Comments for Planning Application 20/01296/OUTMAJ

Application Number: 20/01296/OUTMAJ

Address: Land Off School Lane (South Of Shireshead Cricket Ground) Forton Preston Lancashire PR3 0AS

Proposal: Outline application for up to 41 dwellings (30% affordable), public open space and associated infrastructure with access applied for off School Lane (all other matters reserved)

PROPOSED SITE PLAN:
 CLIFTON HOUSE FARM, SCHOOL LANE, FORTON, PR3 0AR

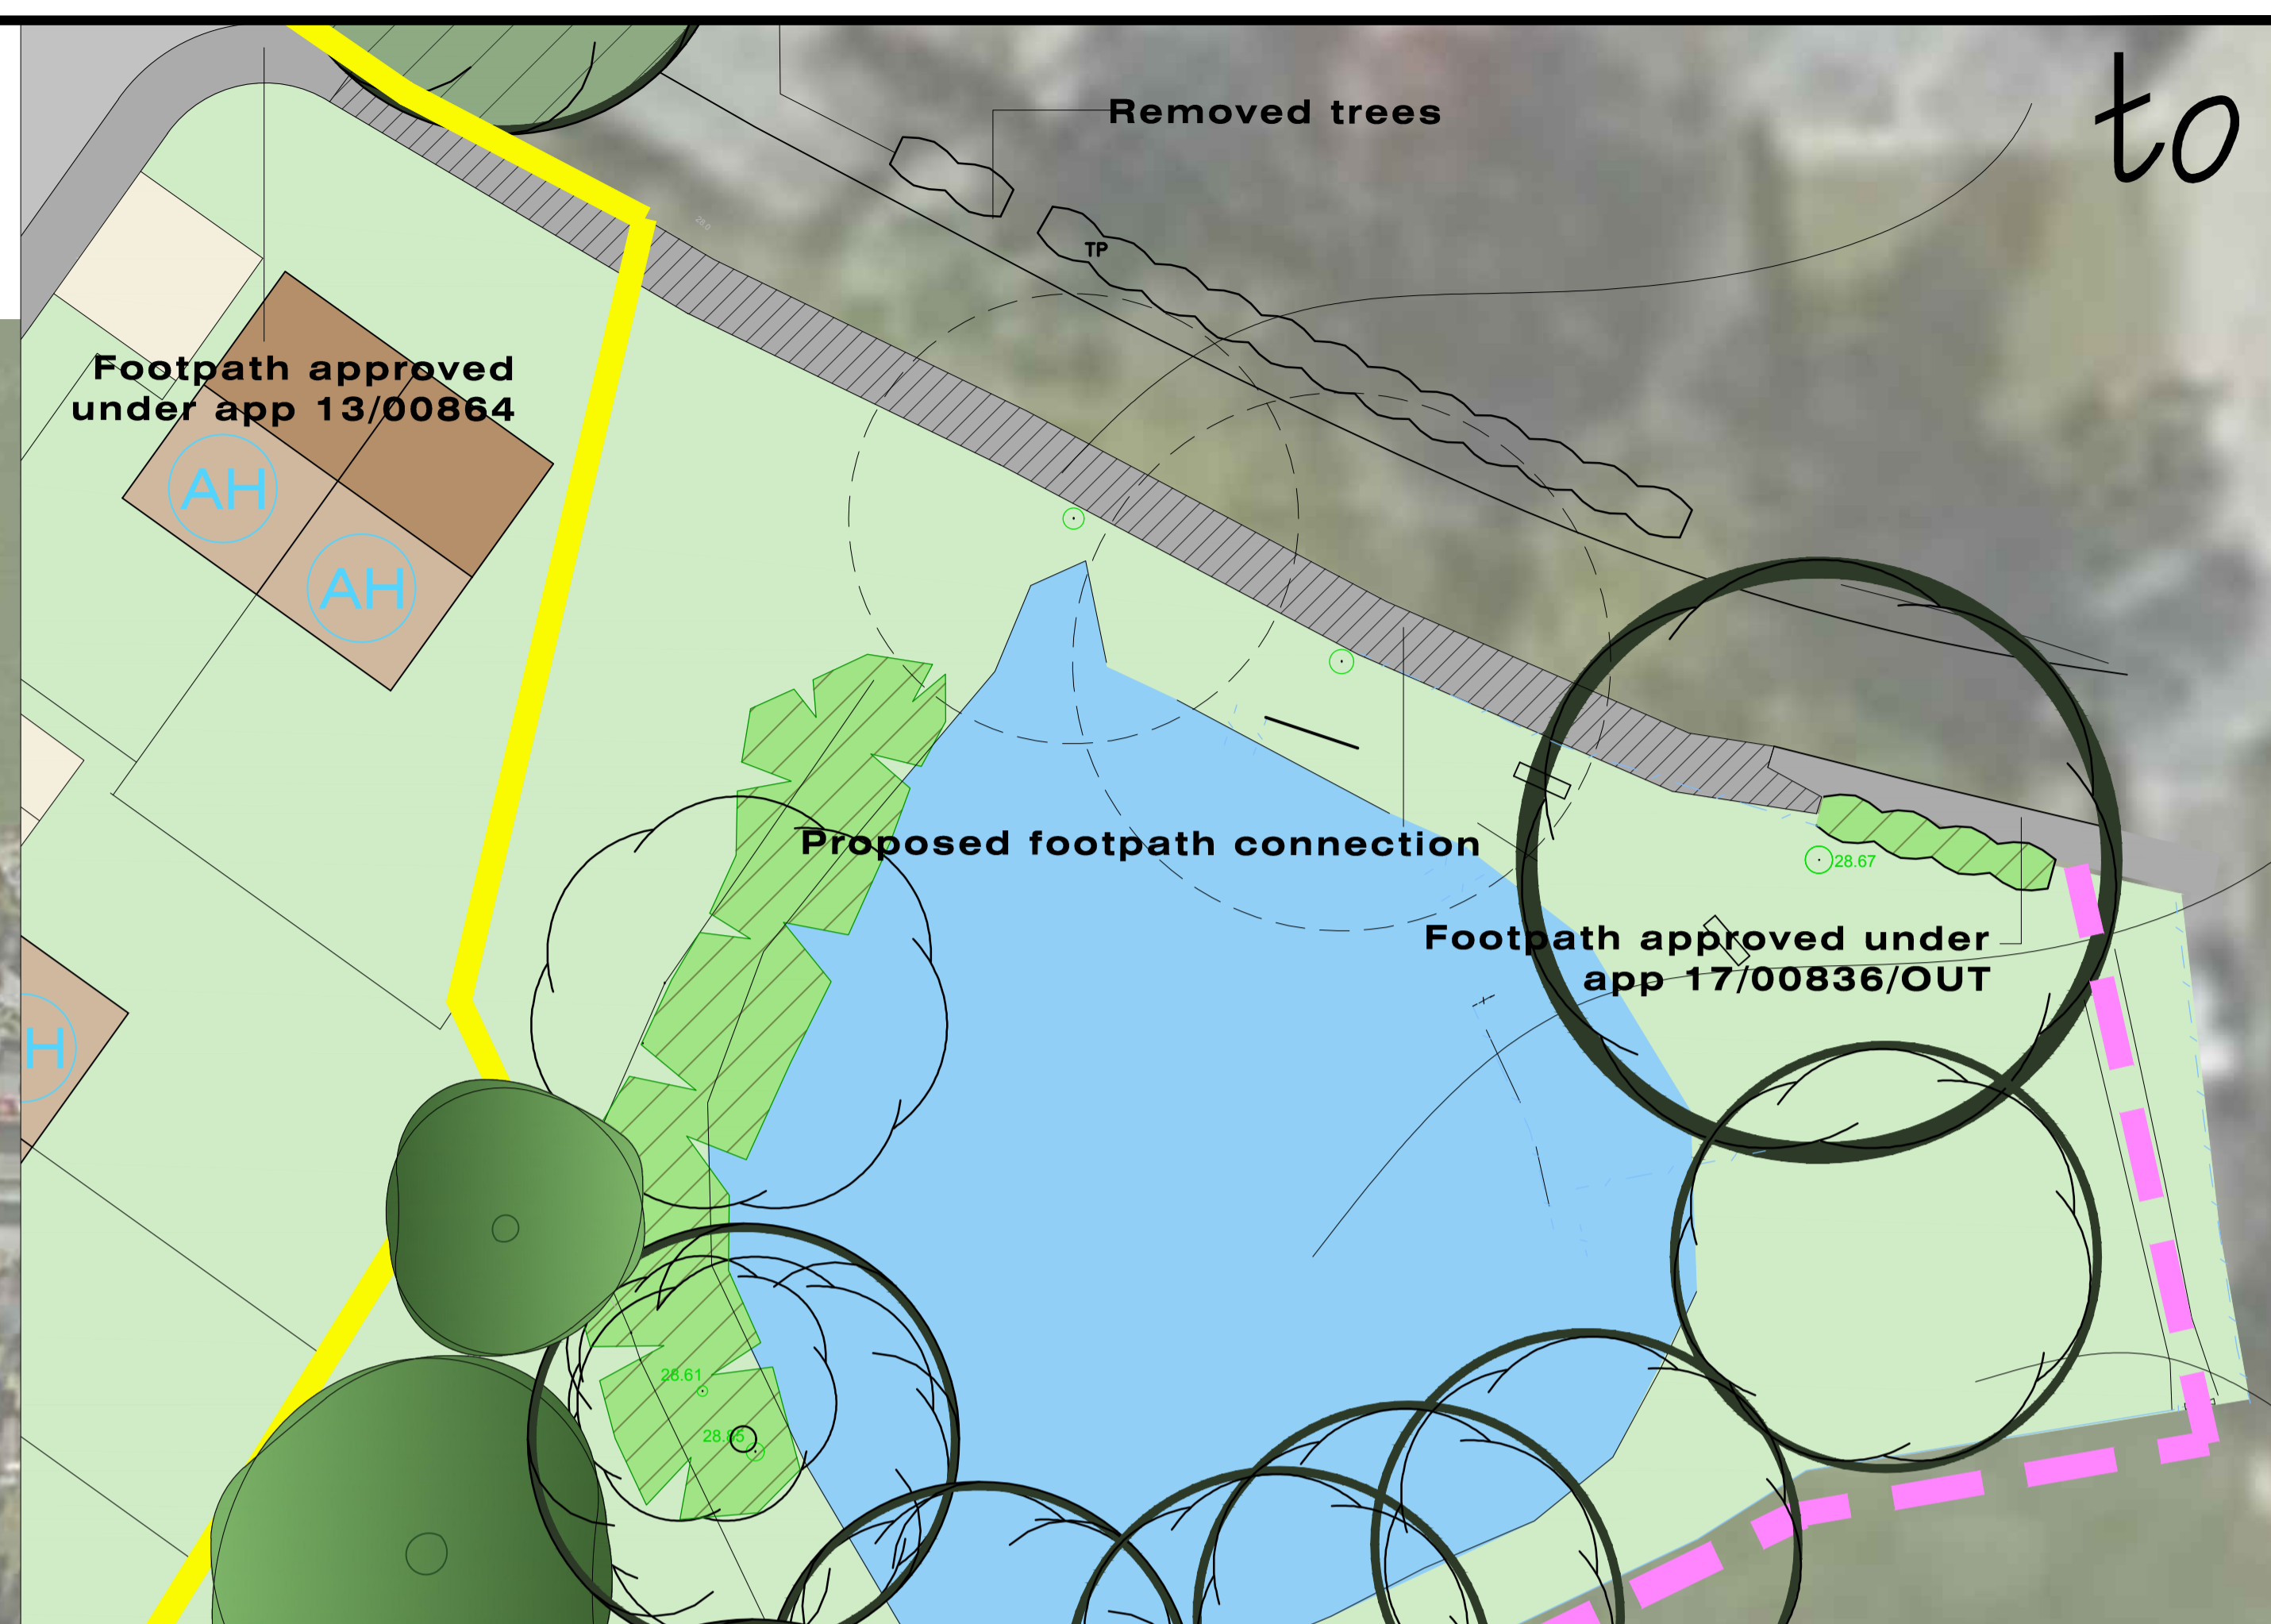
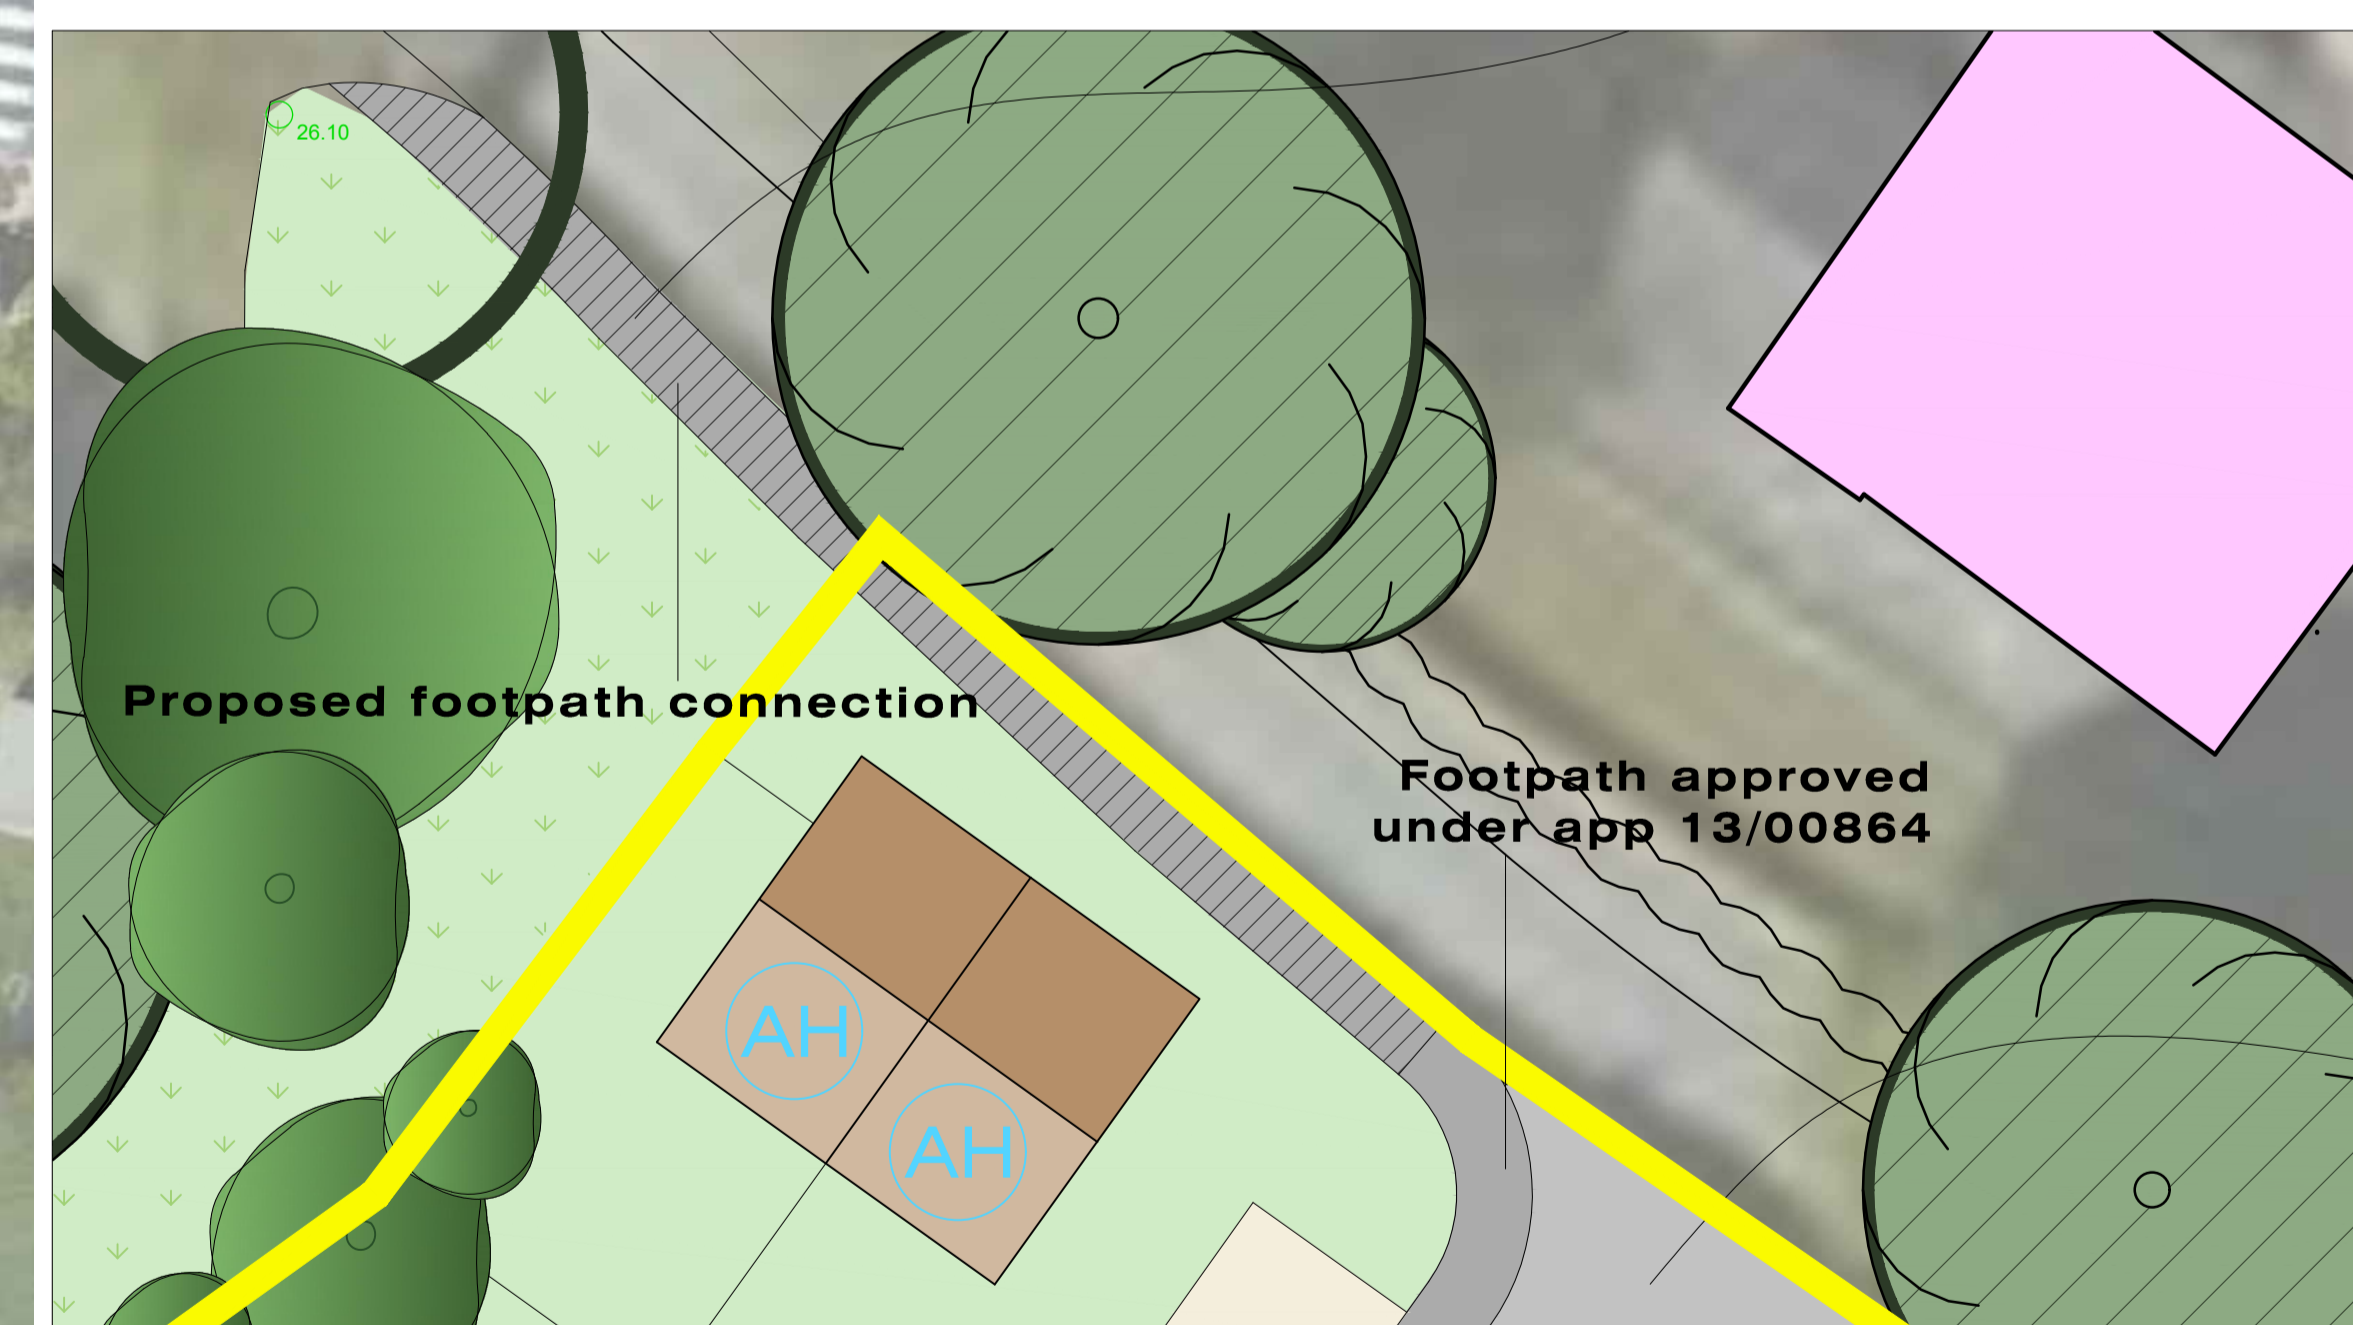
The submitted plans show the line of the pipeline and the easement taken for its construction, maintenance and management. This easement area does not indicate or reflect the hazard area which would be affected if an incident were to take place.

Although this is a comparatively small development the plan shows connections into adjacent fields which suggest this could be part of a series of creeping small future developments which would undermine the whole purpose of local planning.

Footpath provision along School Lane is totally inadequate to service the proposed development.

alongside. Footpaths between the proposed development the school and the A6 predominately do not meet this standard. Even where there are existing footpaths they are too narrow and several crossings of School Lane are necessary to take advantage of these.
